**Town & Country Planning Act 1990 (as amended)**  
**Town and Country Planning (Development Management Procedure) (England) Order 2015**  
**Application for approval of matters reserved by condition imposed under A/167/14/PL relating to**  
**conditions 4, 13, 14, 18, 20 & 23 for protection of retained trees, programme of archaeological work,**  
**ecological mitigation report, foul water sewerage disposal, surface water drainage & storage of**  
**refuse & recycling bins.**  
**Former Pound Nursery Roundstone Lane, Angmering,**

**Condition Number 18**

Arun District Council have decided to **REFUSE details reserved by condition for the following reasons:**

TITLE
Site Layout
Section 104 Agreement Plan

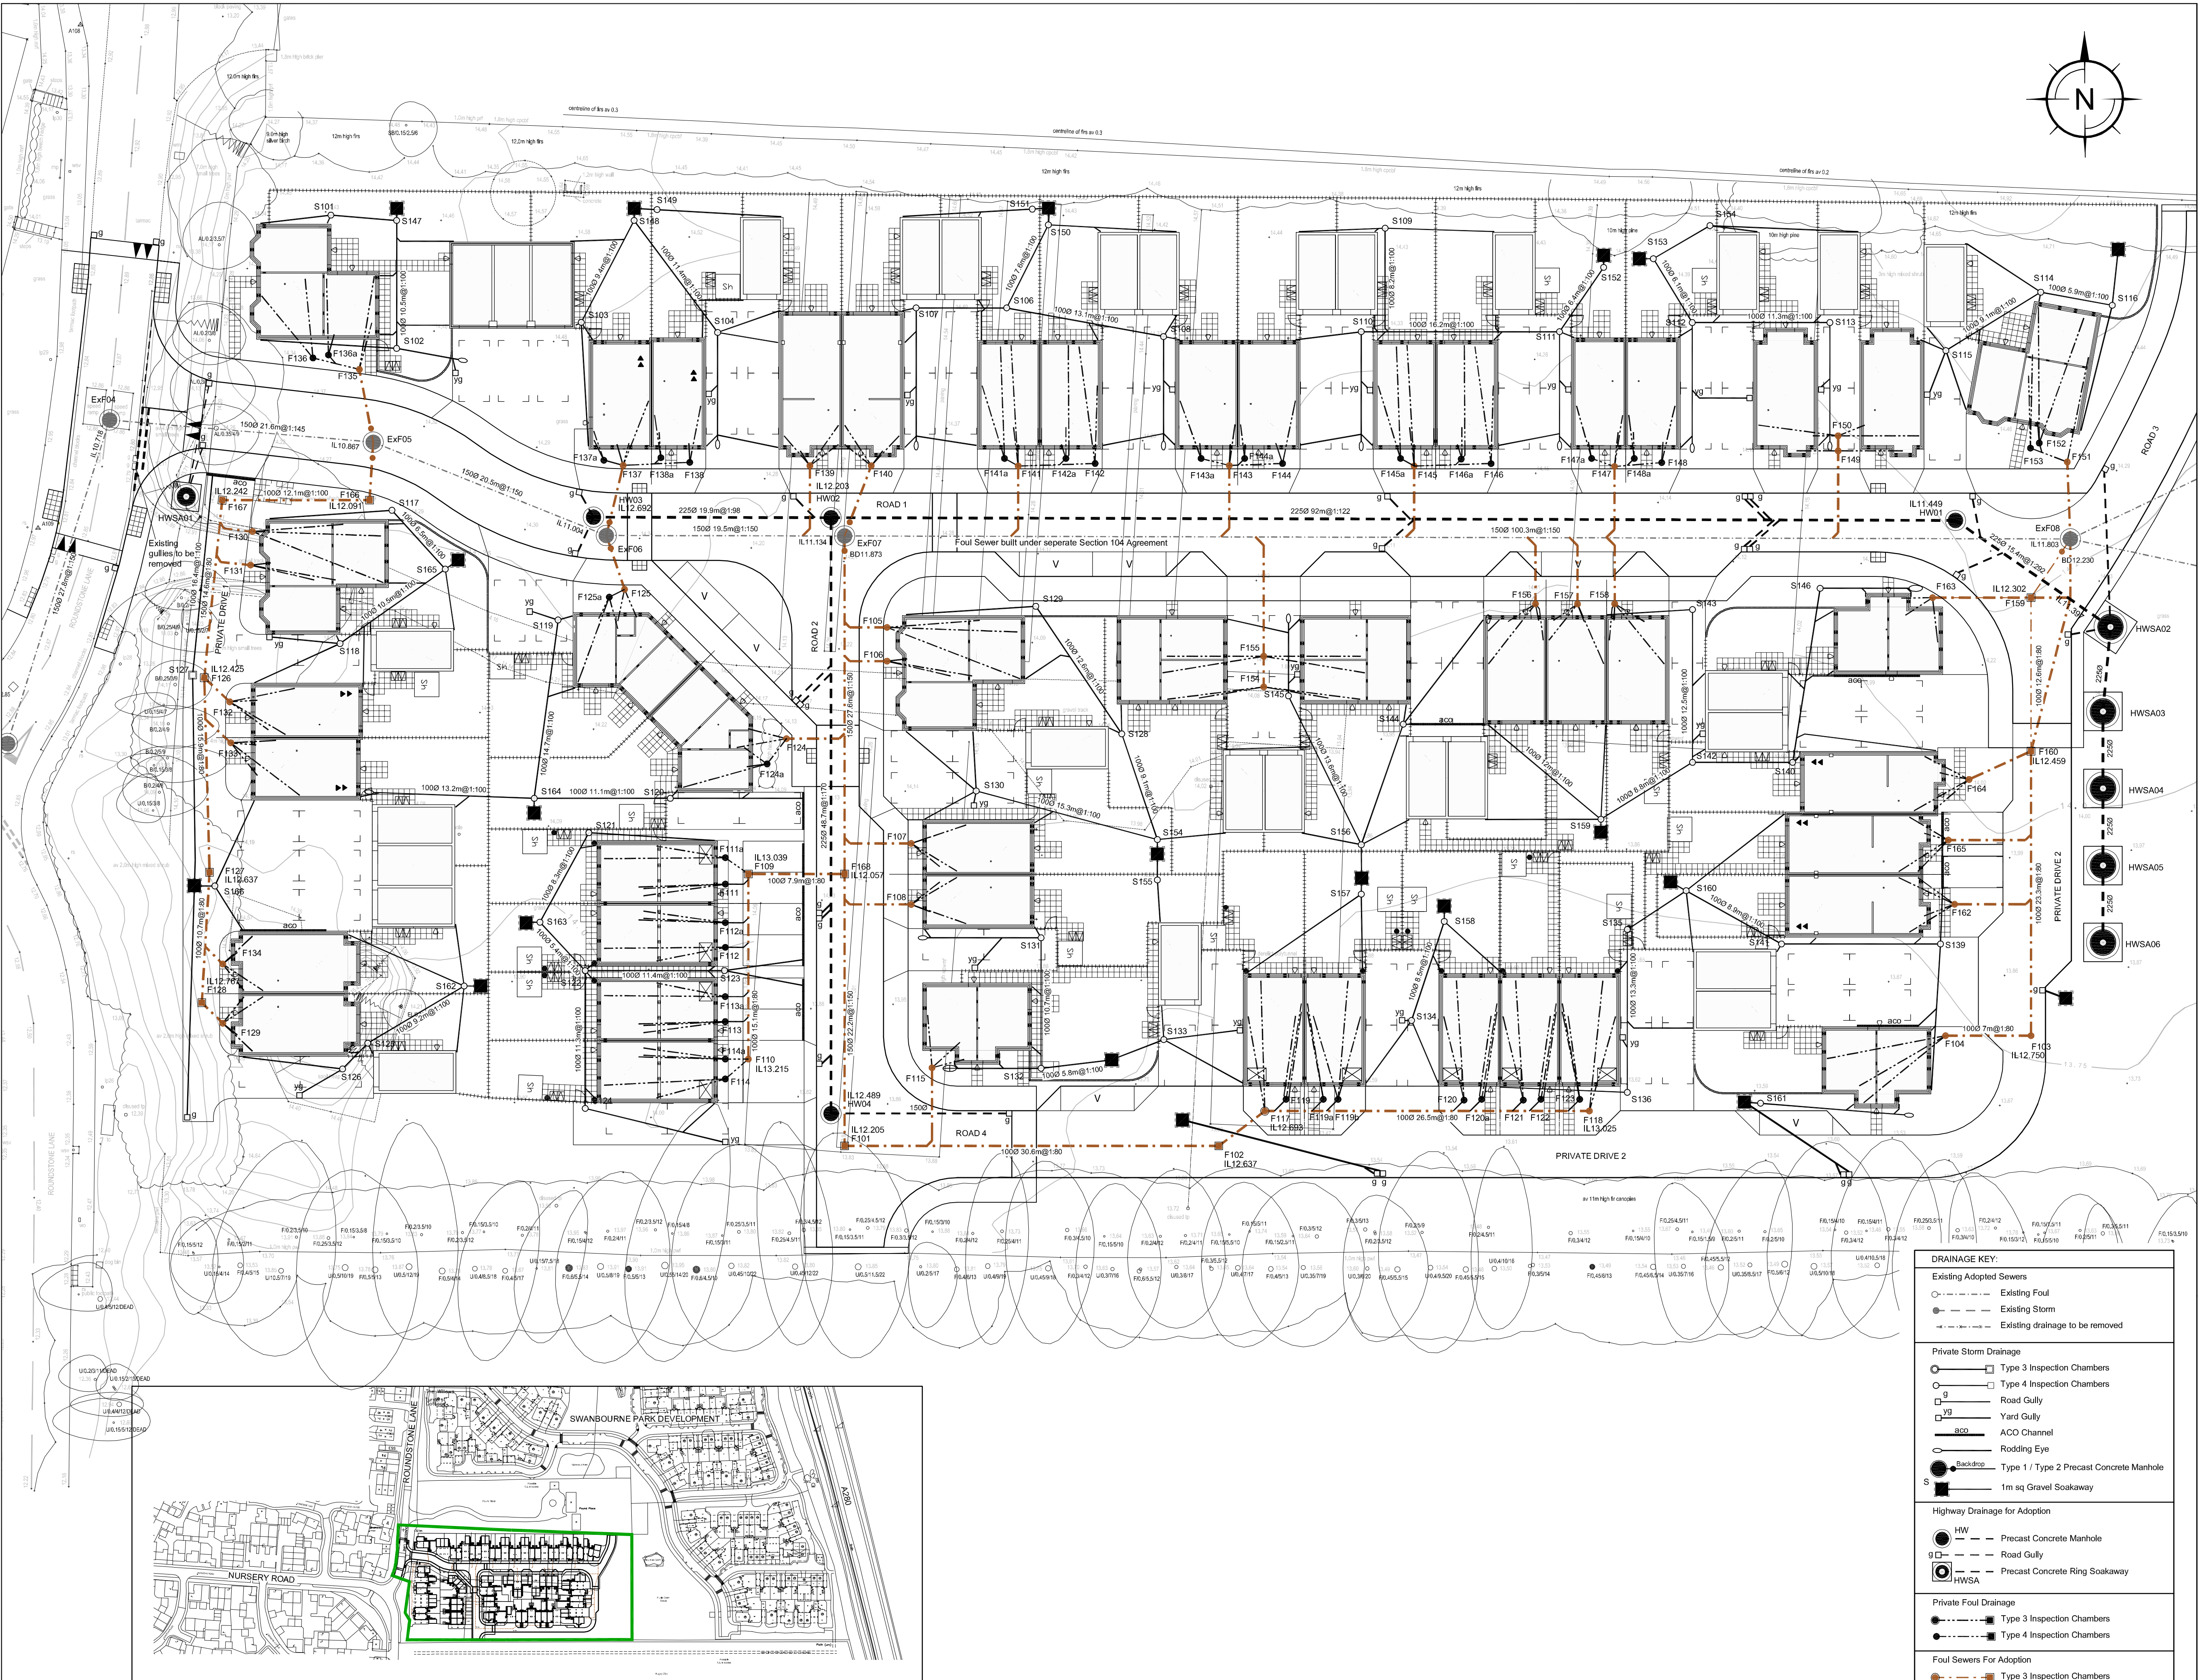
The details submitted do not comply with Southern Water's adoption standards.
